HARNETT COUNTY

DEPARTMENT OF PUBLIC HEALTH

March 14, 2002

RE: Harnett County Land Use Application #01-5-3874

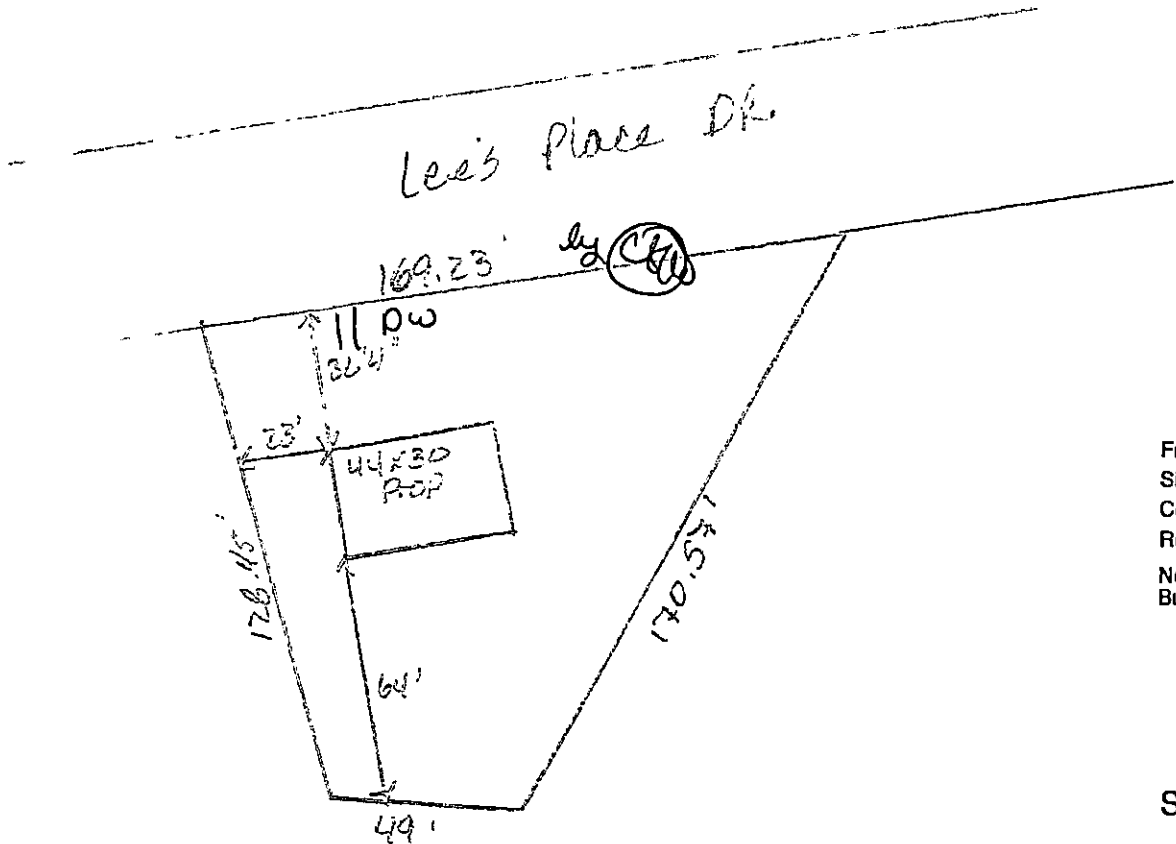
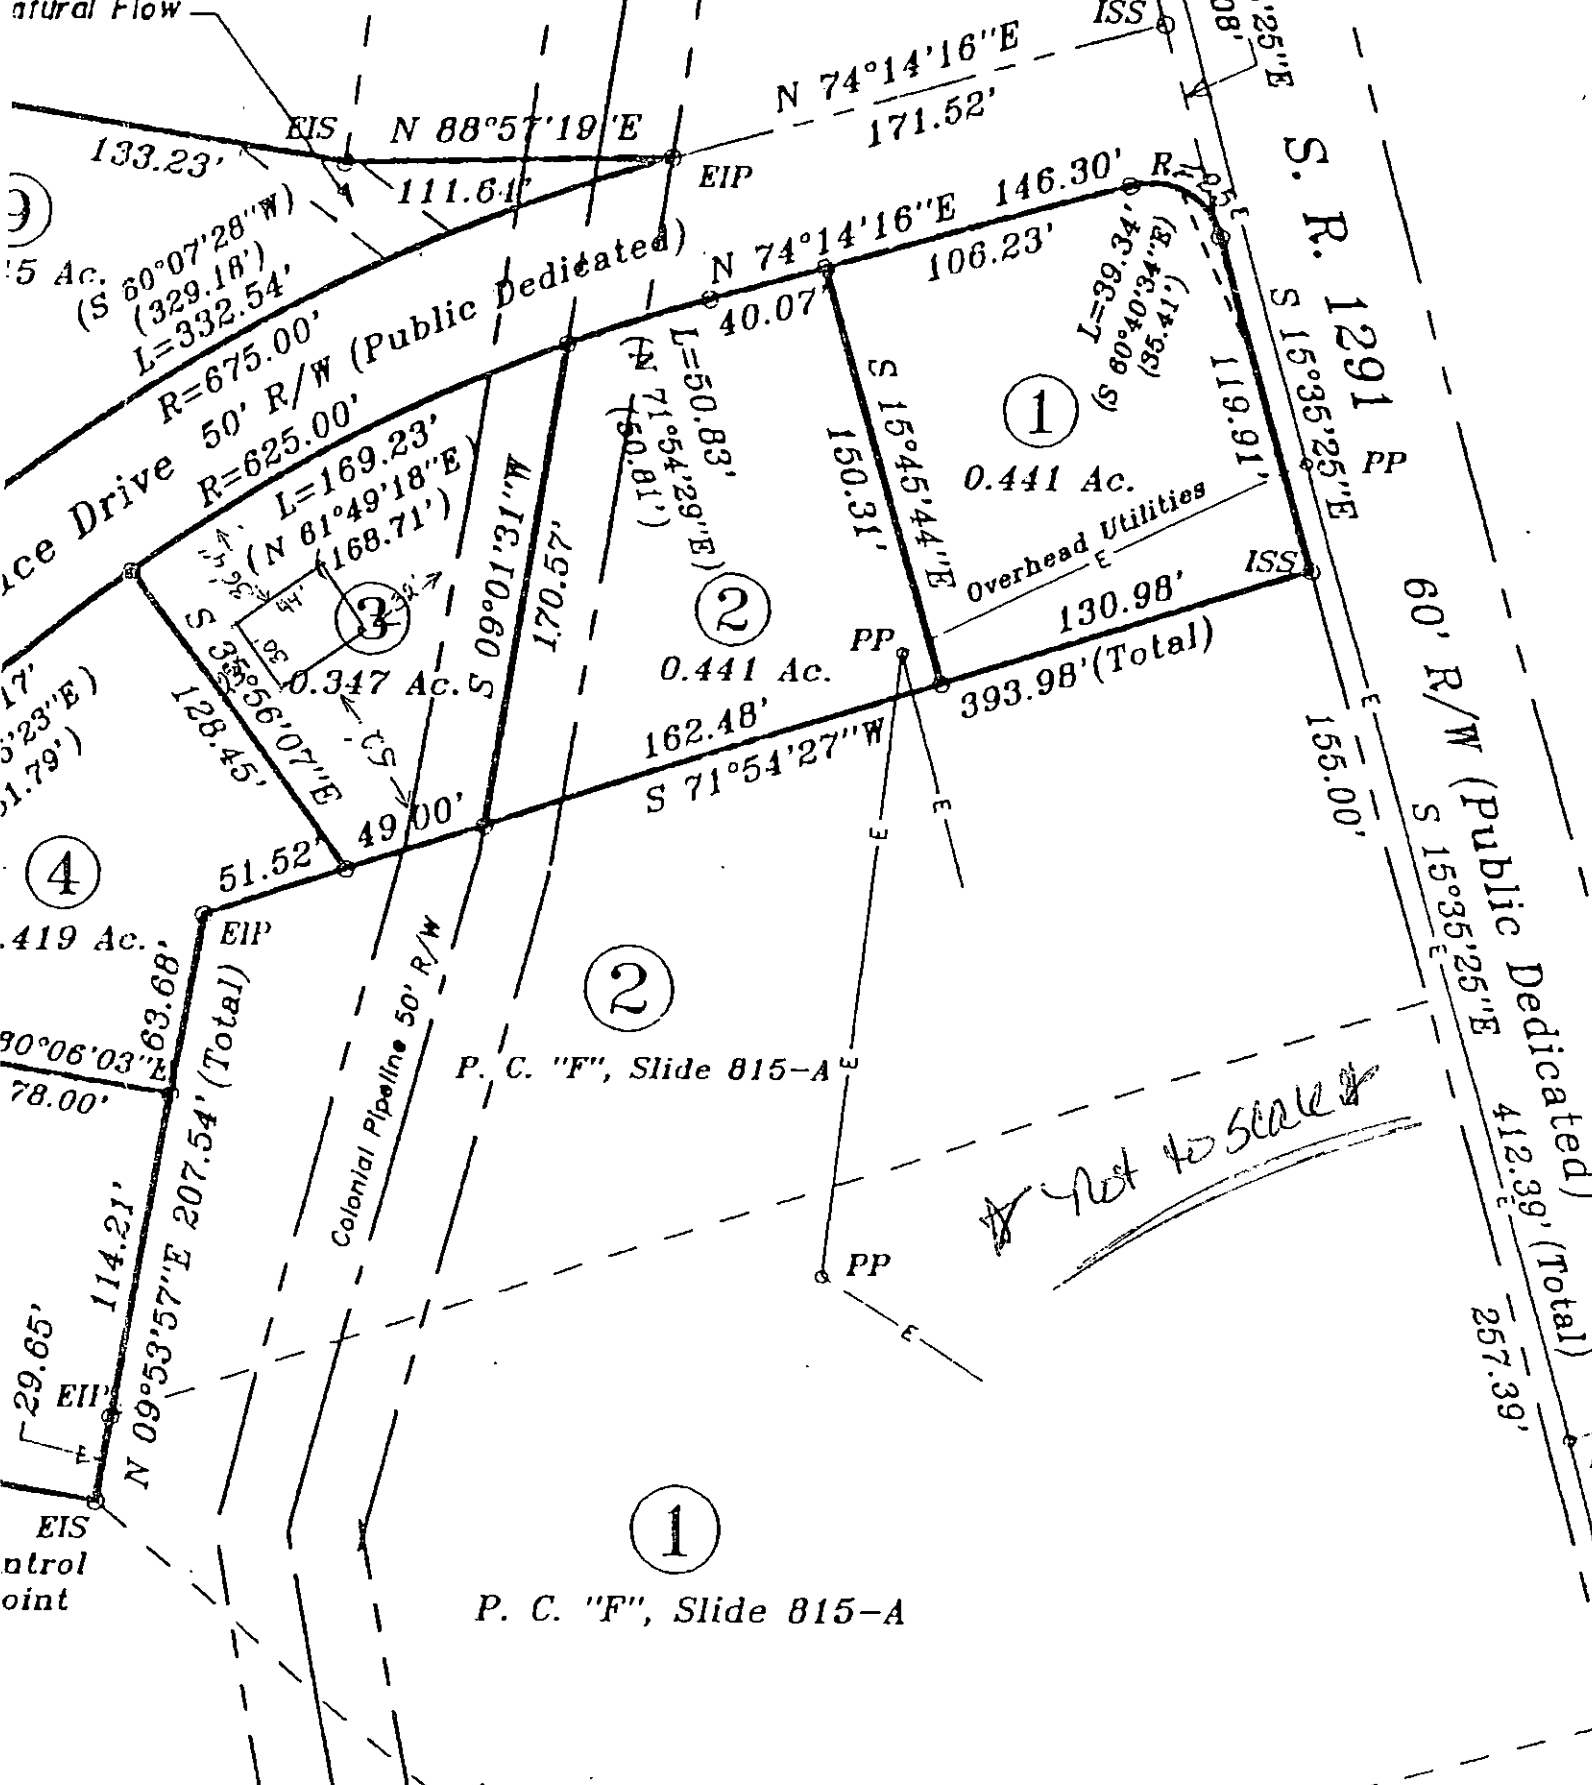
Upon reviewing the work submitted by Southeastern Soil & Environmental Associates, the Harnett County Environmental Health Specialist has found a problem with the maps you have submitted for Lee's Place Lot #3. According to the maps submitted by you, the rear property line is 49' wide with 25' of that in the right of way for the gas line. This map is consistent with maps submitted by Hamilton Builders for Lot 2 and with the map that was submitted for the development. At this time it appears that this lot will require a Low Pressure Pipe System. You will need to have a private consultant design a Low Pressure Pipe System and submit the design to the Health Department.
